# CITY OF ALBUQUERQUE

**Re: Cottonwood Classical – Portable Addition**  
**7801 Jefferson St NE**  
**Traffic Circulation Layout**  
Architect's Stamp 05-19-2021 (D17-D003A)

Based upon the information provided in your submittal received 07-06-2021, the above referenced plan cannot be approved for Building Permit until the following comments are addressed:

TRAFFIC CIRCULATION LAYOUT

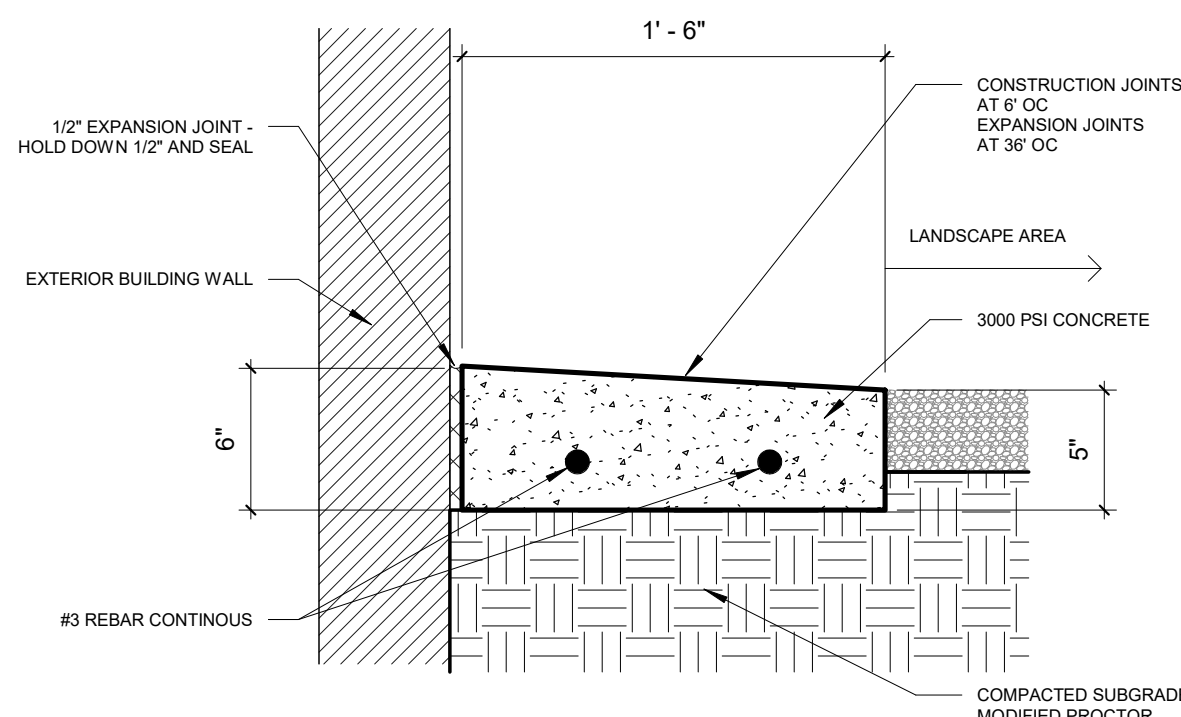
1. **Please show a vicinity map showing the location of the development in relation to streets and well known landmarks.** Vicinty map added to TCL plan.

2. **List the number of parking spaces required by the IDO as well as the proposed number of parking spaces including bicycle and motorcycle parking. Discuss with Zoning.** Revised.

3. **The proposed Modular Buildings;**
  - **Three buildings are blocking 7 stalls. Has the deletion of these stall been included in the over all parking calculations?** Deletion has been included into calculations.

- **Does these buildings need parking stalls? Especially ADA parking to service these buildings? Since the existing parking lot has no striping to delineate individual stalls.** Parking not needed. 2 ADA parking stall within 50 yards.

- **Provide dimensions for drive aisle leading into existing parking lot.**
4. **Activity area adjacent to entrance drive aisle appears to be proposed or is it existing. Please label this area as either existing or proposed based the line type.** Revised.

6. **Label all street names on site plan.** Revised.
7. **Site Plan sheet : Sheet title calls out for Traffic Control Layout. This is incorrect. Please label the sheet as CIRCULATION and not Control. Traffic Control requires a different type of certification from the designer** Revised.
